STATE OF WASHINGTON
DEPARTMENT OF ECOLOGY

December 24, 2014

Re: CU-14-00005

Thank you for the opportunity to comment during the optional determination of nonsignificance process for the farming operations related to KC 17.15.060.1 A – Marijuana Processing and Production on a 15.03 acres parcel, proposed by Mary Gonzalez. We have reviewed the documents and have the following revised comments.

Drawing file: CU-14-00005 McDonald / CU-14-00005 McDonald Site Plan.pdf

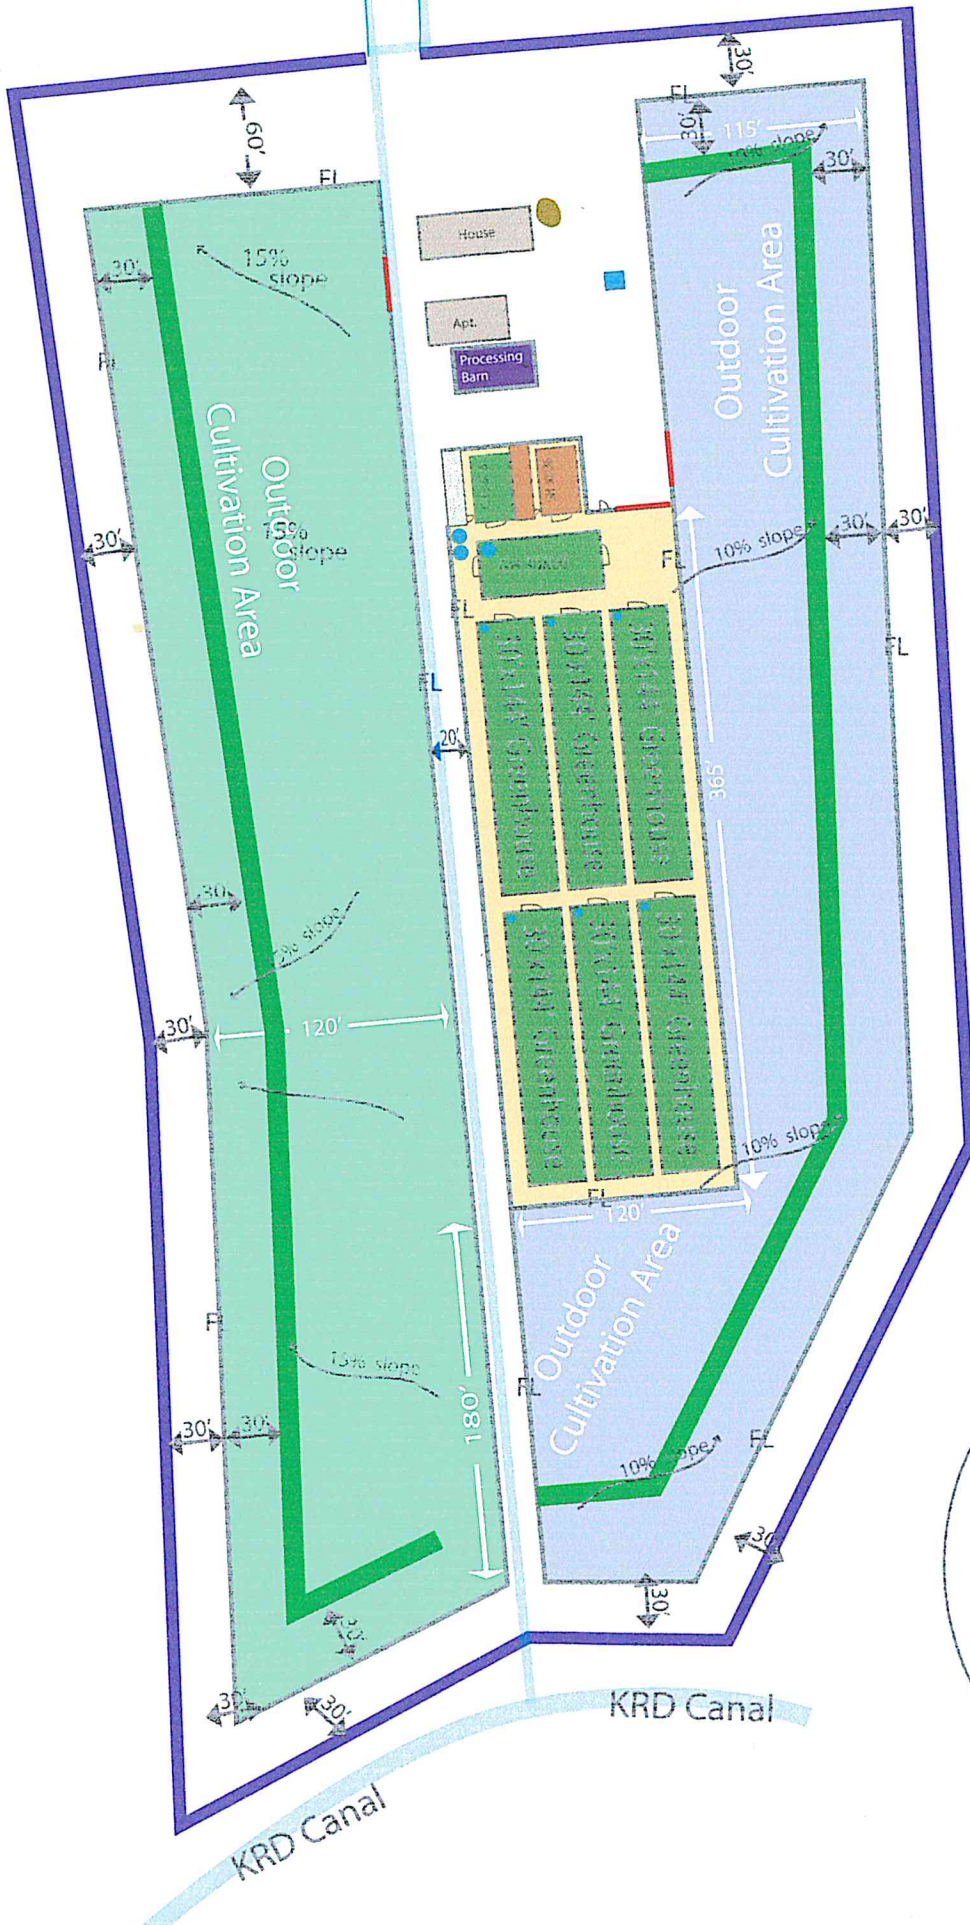
Ecology recommends that all phases of the commercial cannabis growing development be described in this environmental checklist form. A site plan was available, but very little details of the plan were included in the environmental checklist answers. No build-out information, such as total square feet of impervious surfaces or square feet per phase, was provided to this reviewing agency.

The wetlands on site should be delineated and rated to assure that appropriately sized buffers are in place throughout all phases of the project to protect the wetland functional values. In later phases of the project, the buffer from the wetlands is proposed to be cut in half to 60 feet. At this size buffer (combined with a slope) only 50 to 70 percent of nutrients being applied on the surface could expect to be treated by an intact vegetated grass buffer. The impacts of the use of fertilizers on the adjacent wetland should be evaluated. Measures that will be employed by the applicant to protect the water quality and other functional values of the wetlands on site should be described by the applicant. Periodic assessment of the impact of the project on adjacent wetlands is recommended.
